Our Ref: AB/147/08/

25th November 2008

Change of use from shop (A1) to domestic garage (C3)
70A Tarrant Street Arundel

BLOCK PLAN

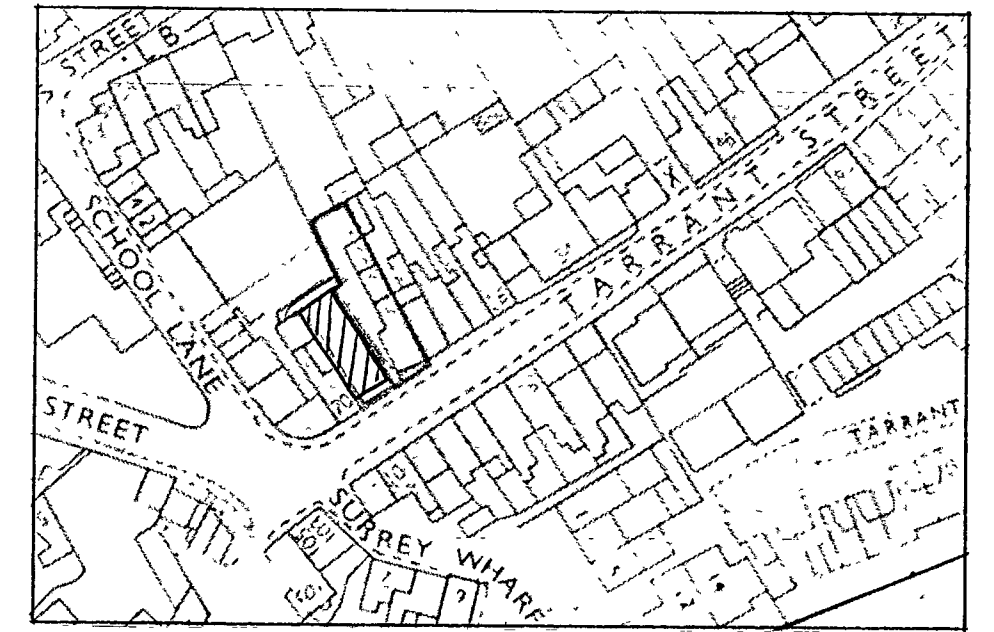
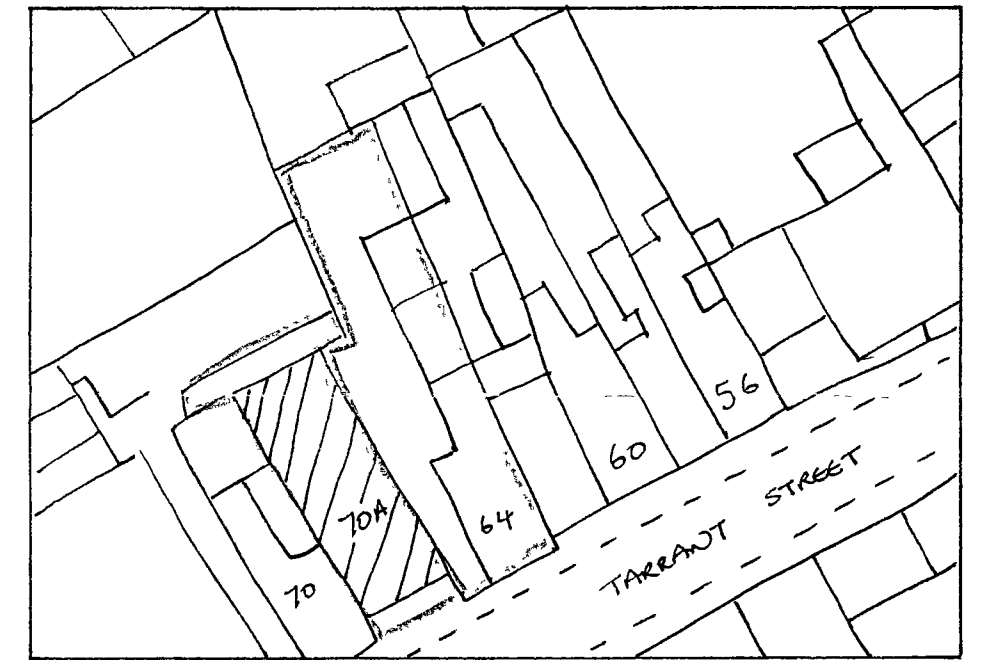
The Arundel Town Council Planning Committee objected to the application on the grounds that the use of the access to the development would cross part of a well used pavement and result in conflict with, and cause potentially dangerous conditions for, pedestrians. Its unsympathetic design and such an inappropriate use would also be out of character and appearance with its surroundings. □
